22 March 2017

RE: 1 Denison Street North Sydney - MP 08_0238 MOD 6; MP 08_0238 MOD 7

I refer to your email of 10 March 2017 inviting North Sydney Council to comment on the proponent's response to submissions. This letter deals with the changes only.

Scale	1 : 250	@ A1
Drawn	WH	Checked JF
Project no.	s12055	
Status	Pre Section 75W	
Plot Date	10/11/2016 5:58:16 PM	
BIM	1DENISON_BS_ARCH	
Drawing no.	DA02.0B1	Revision
		02

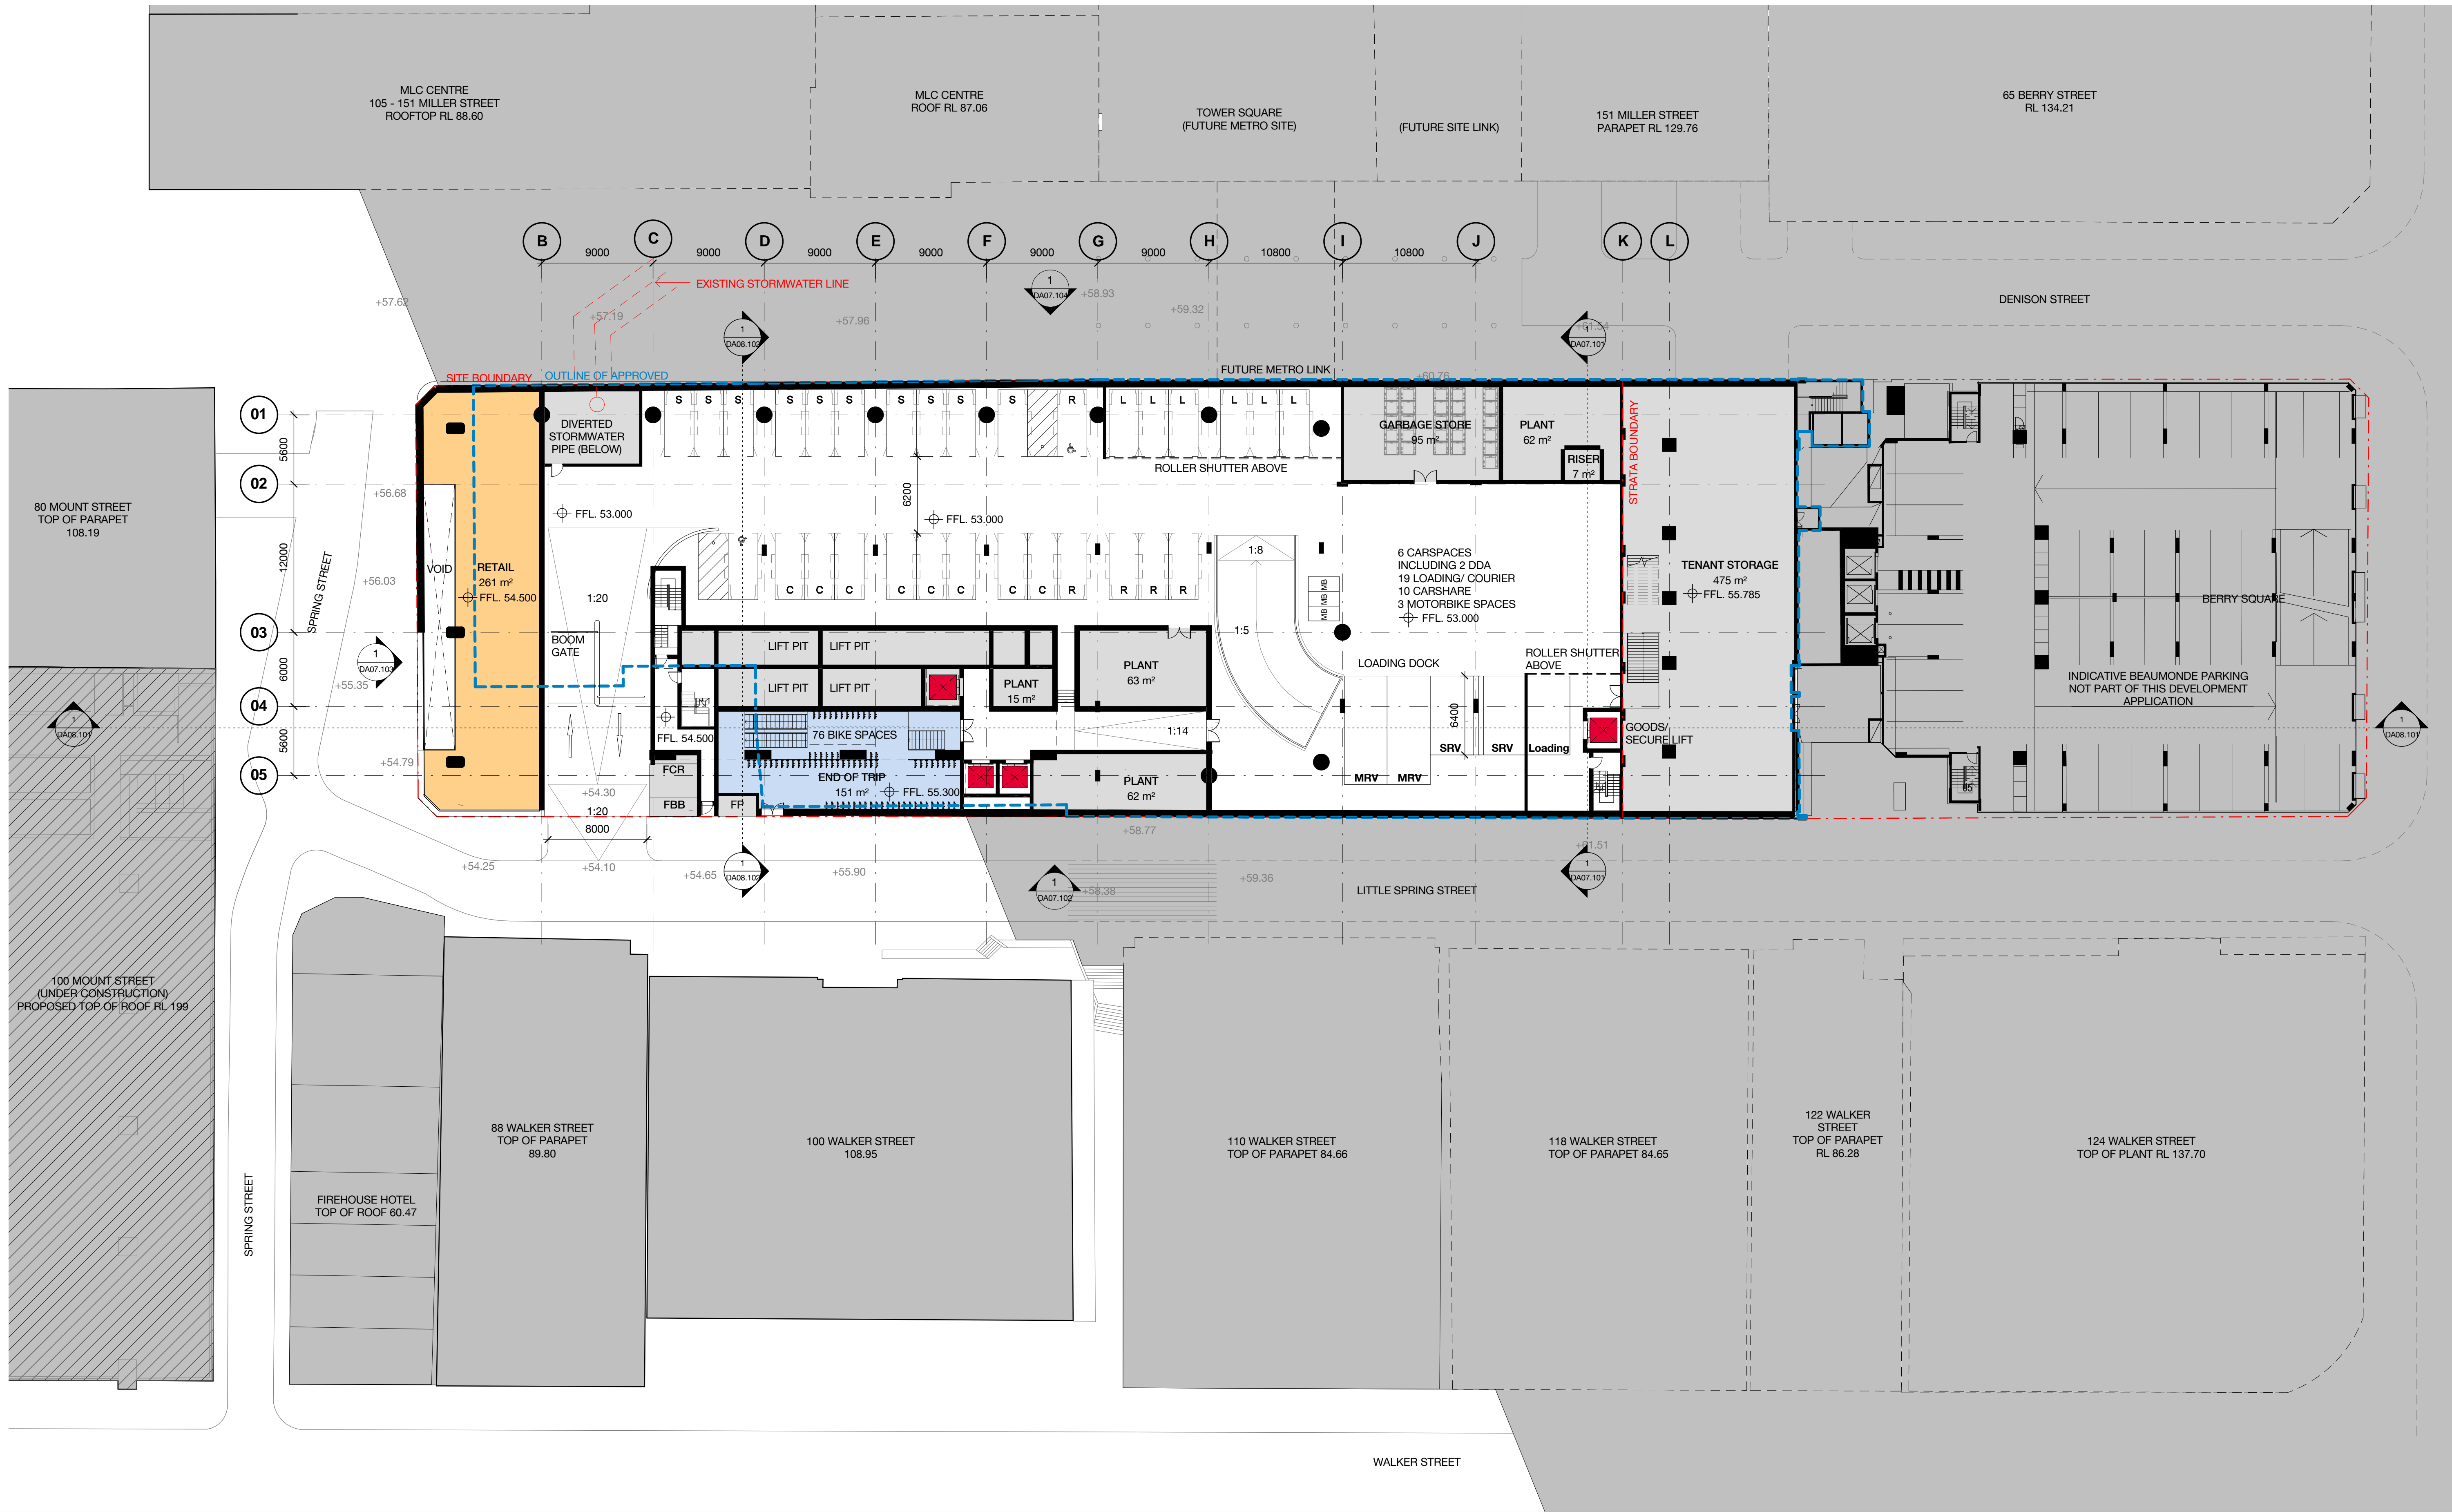
The proposal with regard to the public parking is not acceptable to Council where the proponent retains ownership and management of the public parking spaces. The current approval requires 42 spaces to be allocated to Council. Council therefore seeks to retain condition B5. Council does not have issue with 10 car share spaces but these spaces should be part of the allocation of 42 spaces to Council. The reduction of 27 public motor bike spaces to 21 spaces is acceptable. As detailed previously, Council's position is based on the loss of metered parking spaces as well as other spaces and the substantial revenue lost from those spaces.

The Proponent shall allocate to Council a minimum of forty-two (42) car parking spaces and 21 motorcycle spaces and ~~twenty-seven (27) motorcycle spaces~~ commencing at Basement 1 level of the commercial tower as public parking. Details of the allocation of the required spaces shall be provided to the Department and the Certifying Authority prior to the issue of the relevant Construction Certificate for the Commercial Tower excluding for any initial works.
